Recommendation Report for Planning Permission for Works or Extension to a Dwelling

REF NO: AL/133/21/HH

LOCATION: Mellotron
8 Dukes Road
Fontwell
BN18 0SP

PROPOSAL: Erection of single storey rear extension.

Drawing
PROPOSED FLOOR PLAN

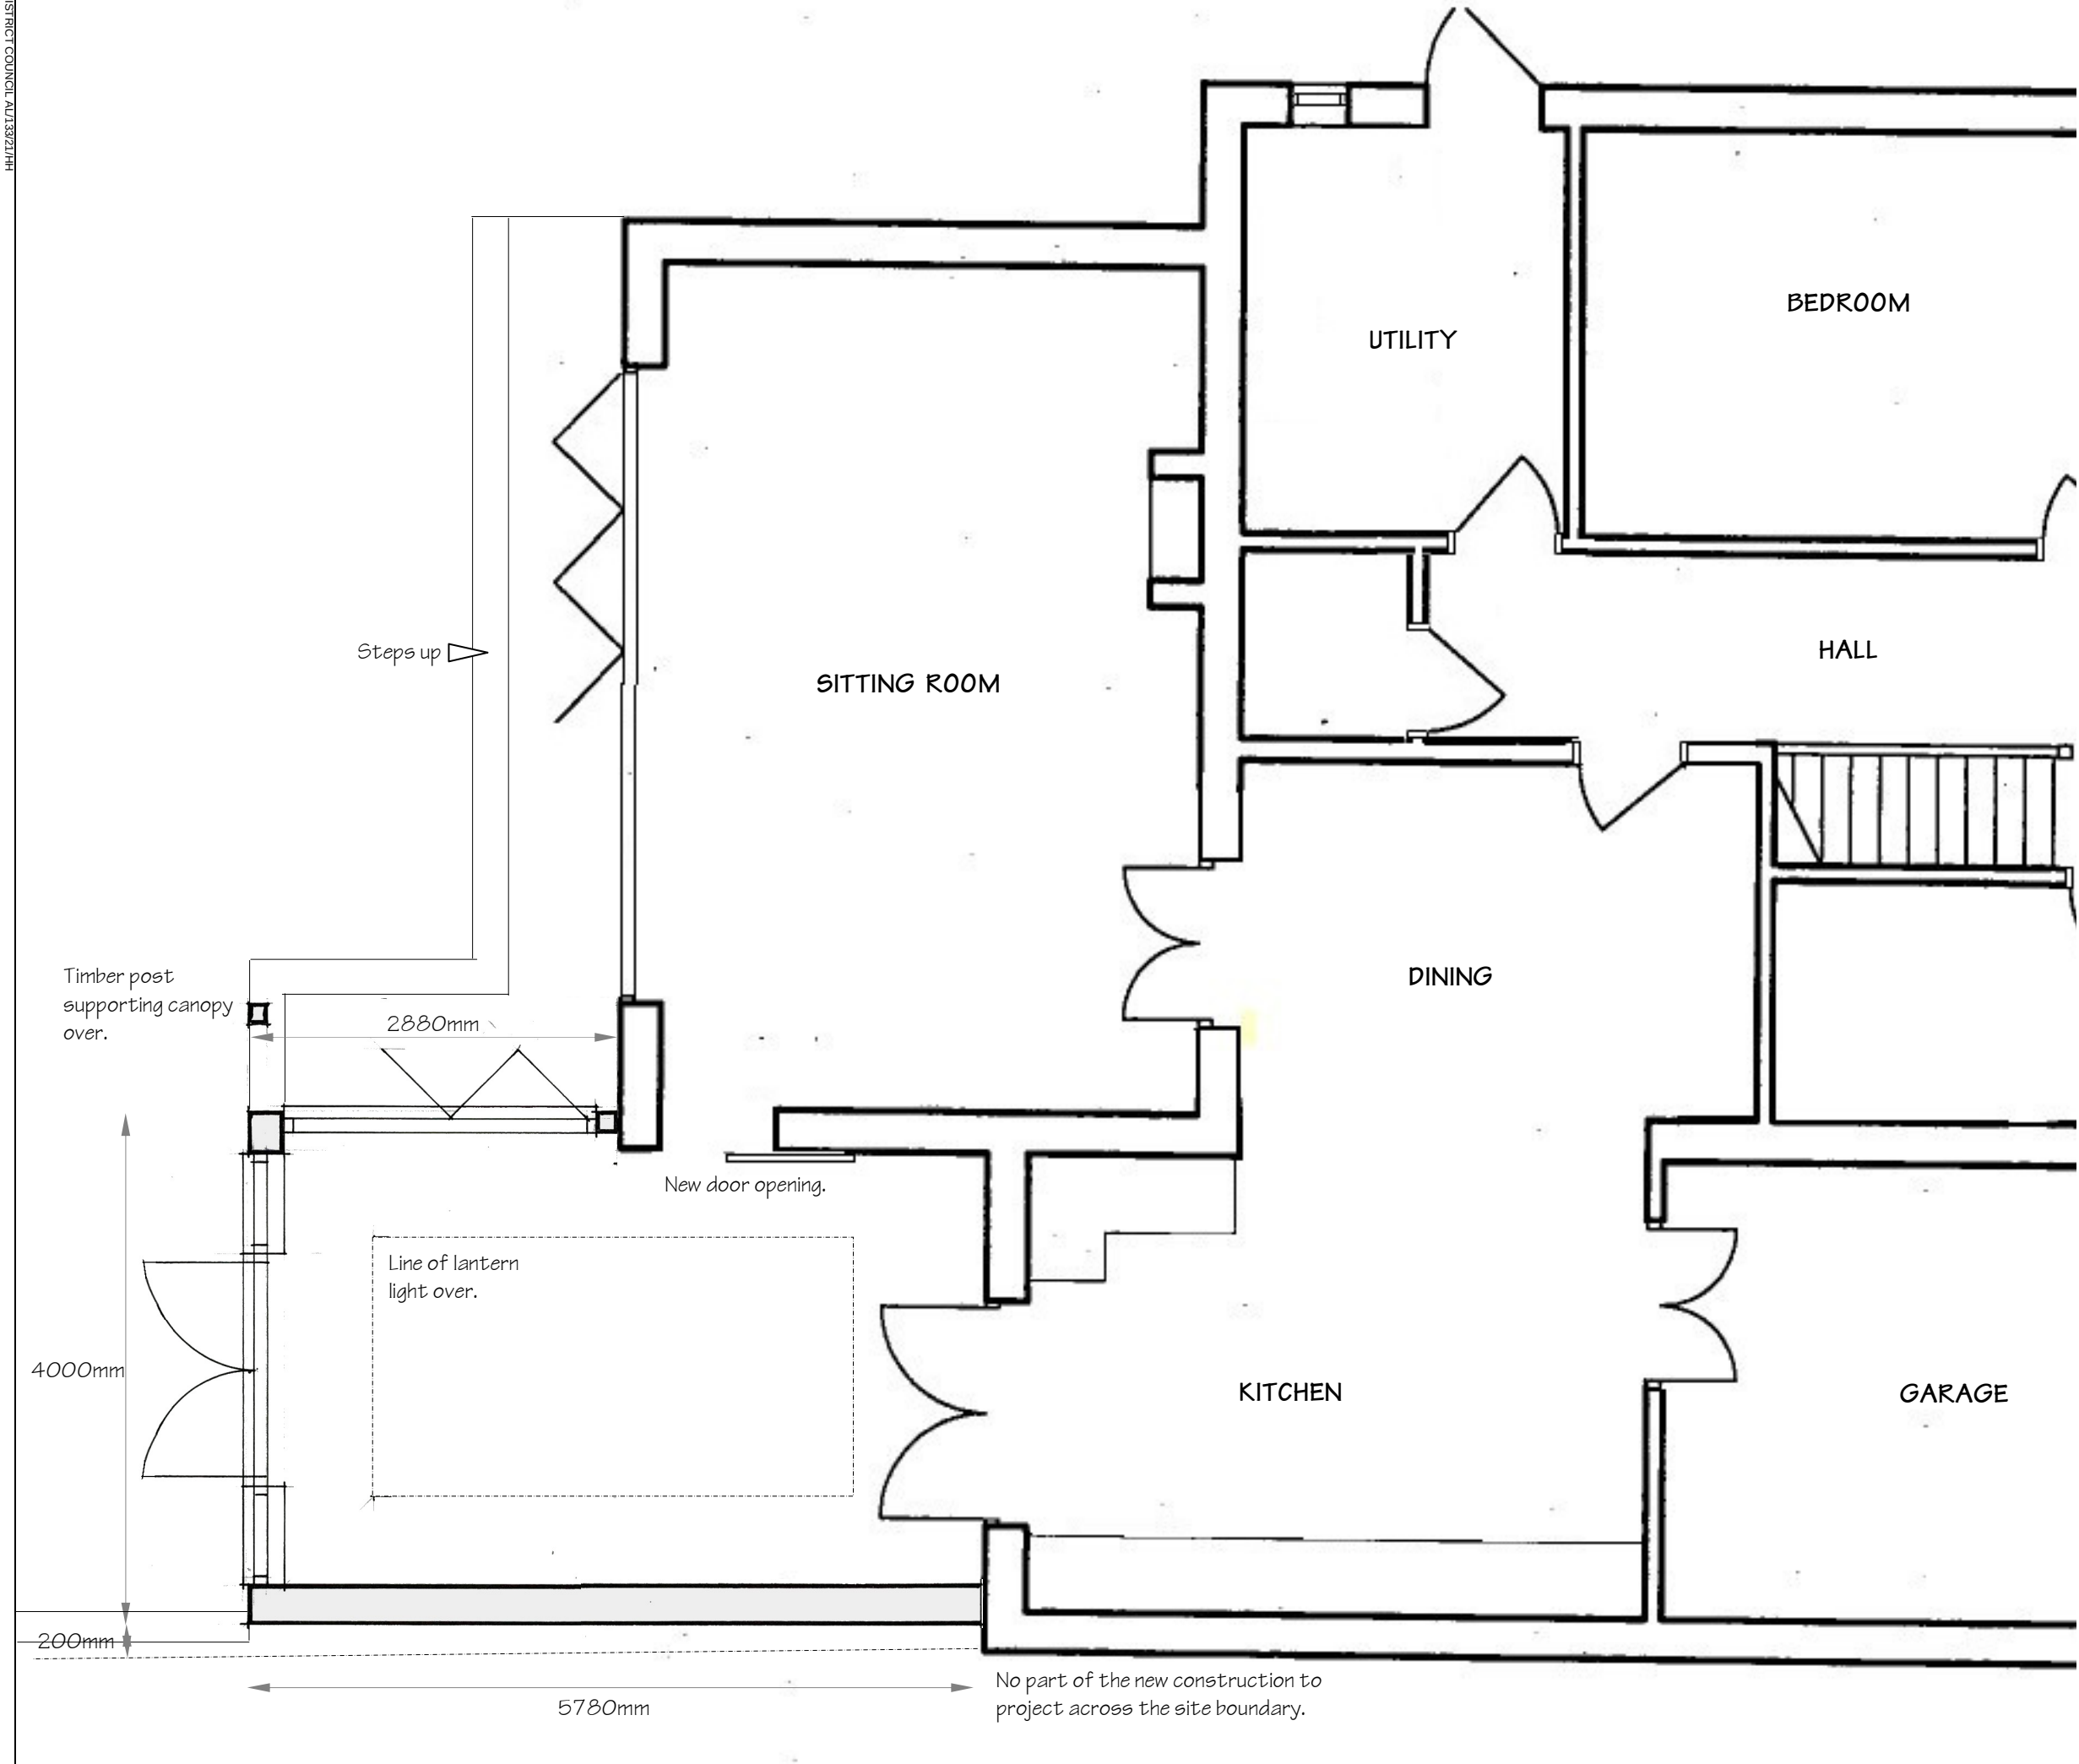
DESCRIPTION OF APPLICATION The application seeks to erect a single storey rear extension with a semi pitched roof design with a flat top at an approx. 4m height and associated roof light. The proposal is approx. 5.7m in depth and approx. 4.3m in width, projecting to the rear from the existing kitchen.

PROPOSED ELEVATIONS

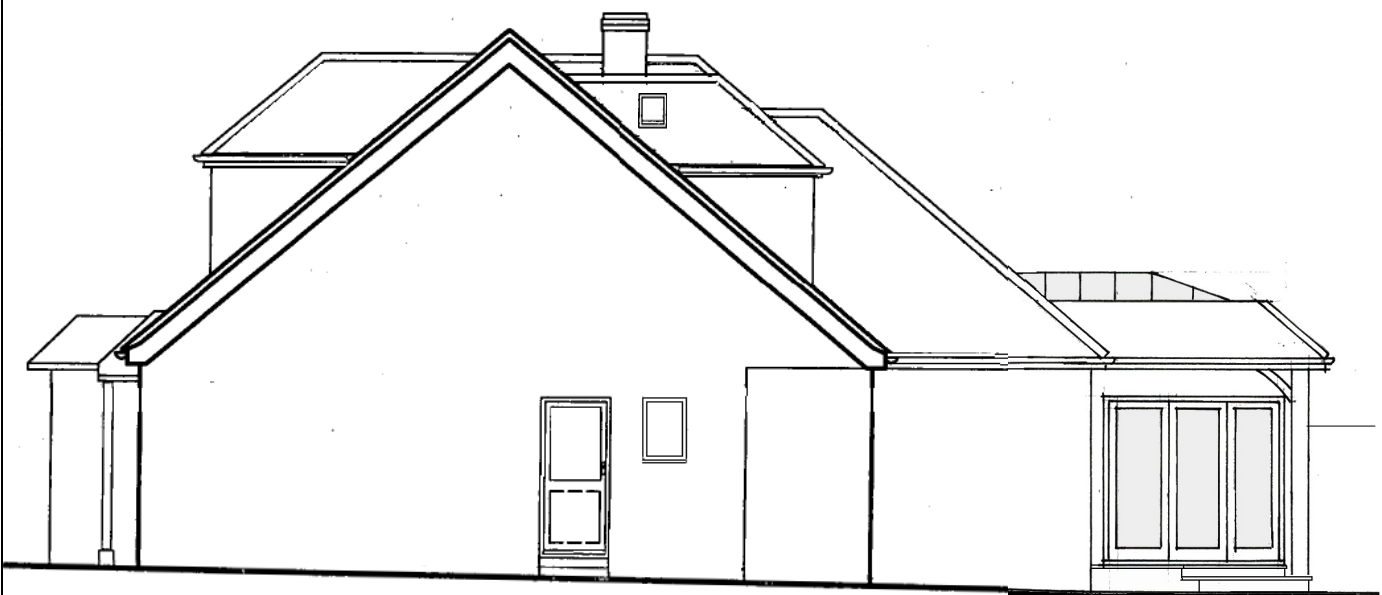
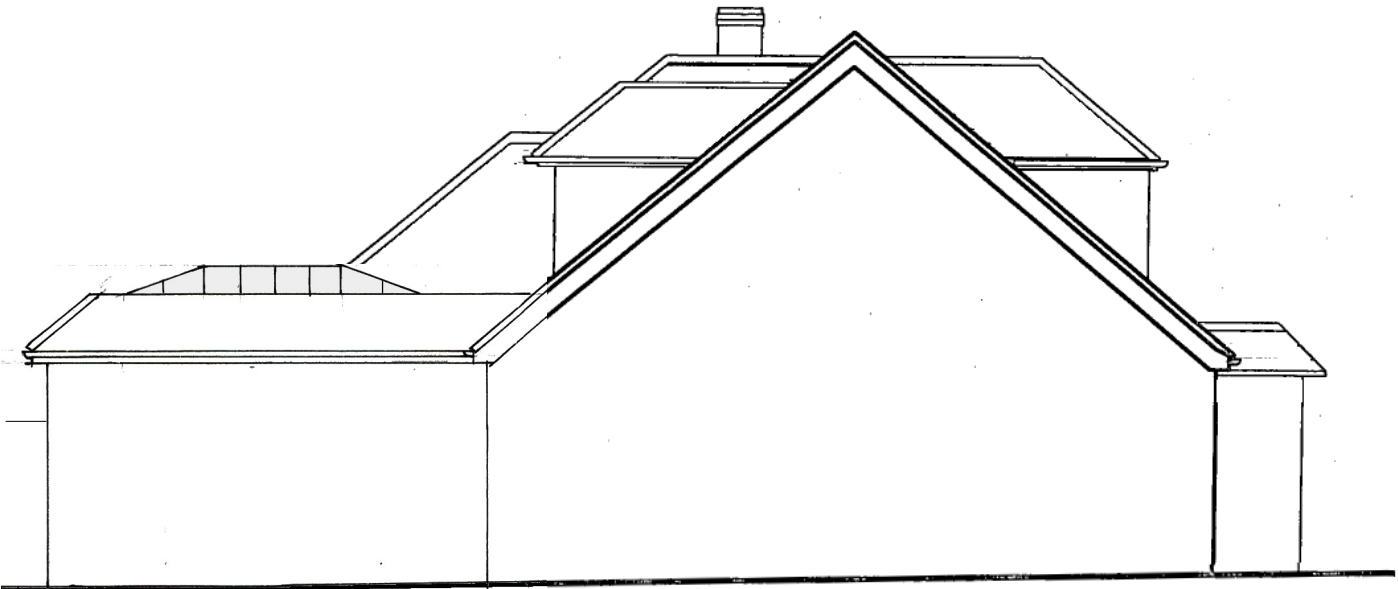
The host dwelling is a large detached property. The proposal is approx. 5.7m in depth and approx. 4.3m in width, projecting to the rear from the existing kitchen. The proposed rear extension projects approx. 2.7m further to the rear of the property than the existing rear extension found on the host dwelling. The height of the proposals roof is approx. 4m with a rooflight that peaks at approx. 4.3m. There are no views

The proposed rear extension sits against the South-East site boundary, neighbouring No. 7 Dukes Road. The proposal projects approx. 5.7m to the rear of the property but does not intersect neighbouring 60 degree sight lines as set out by Section M of the Arun Design Guide. The property at No.7 Dukes Road is separated from the bordering site boundary by approx. 4.5m and has an outbuilding at the site boundary that partially obscures views of the proposal. There is minimal impact (overbearing or overshadowing) due to the single storey nature of the extension.

The proposal includes rear facing glass doors and windows and North-West facing glass doors. The proposal is single storey and the rear facing glass doors and windows provide no adverse impacts by way of overlooking. The side facing (North-West) glass doors look to the North-Western site boundary but retain approx. 8m of distance to the boundary, and does not create overlooking.
